LORSON RANCH COMMERCIAL

TRAFFIC IMPACT STUDY

Revise to Master Traffic Impact Study

Add County Project #
"P-22-011"

**Figure 3. Existing Conditions Traffic Volumes (AM Peak Hour)**

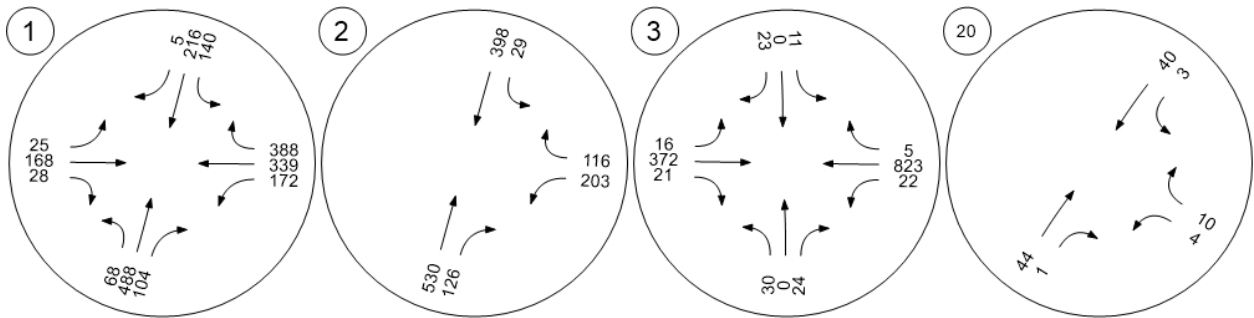
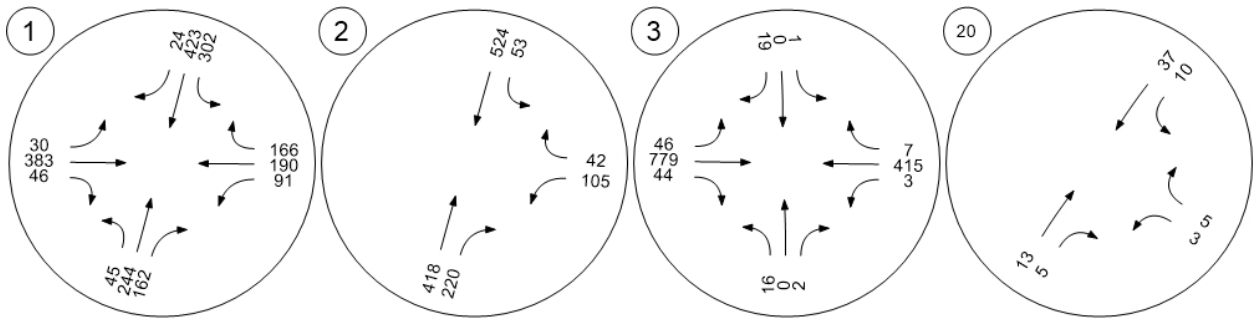
Did not see data for this intersection in Appendix A

Figure 7. Trip Distribution

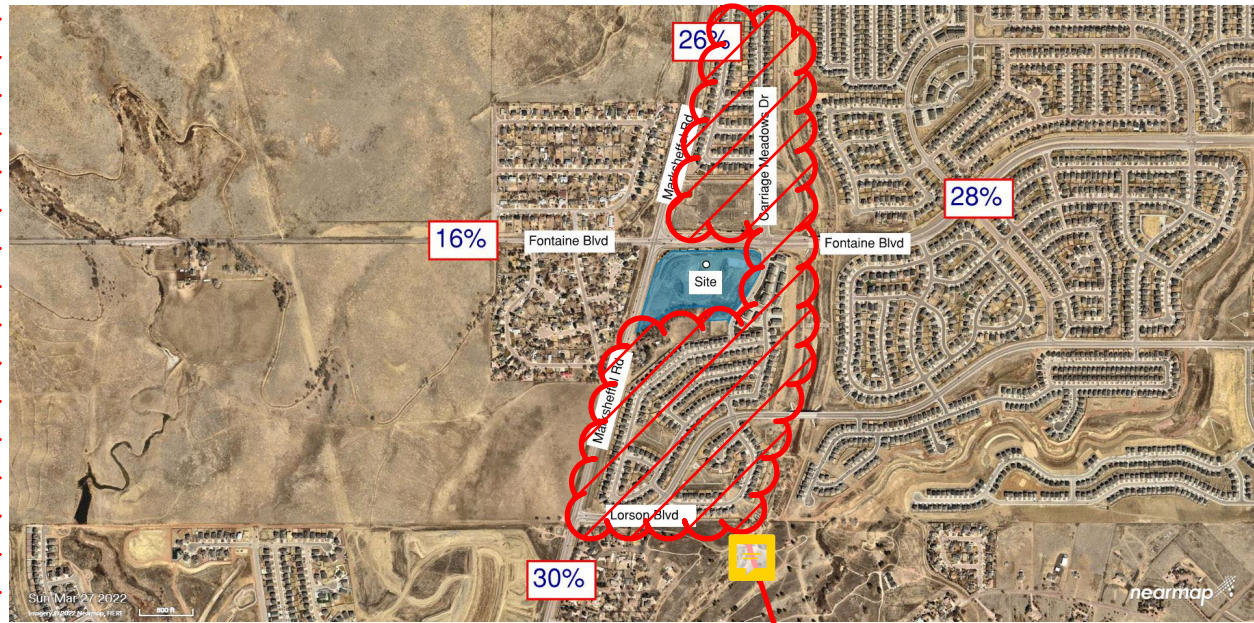
Existing travel patterns will change rapidly in this developing area. Existing volume distributions should not be the only basis for trip distribution. Refer to other studies listed on page 9.
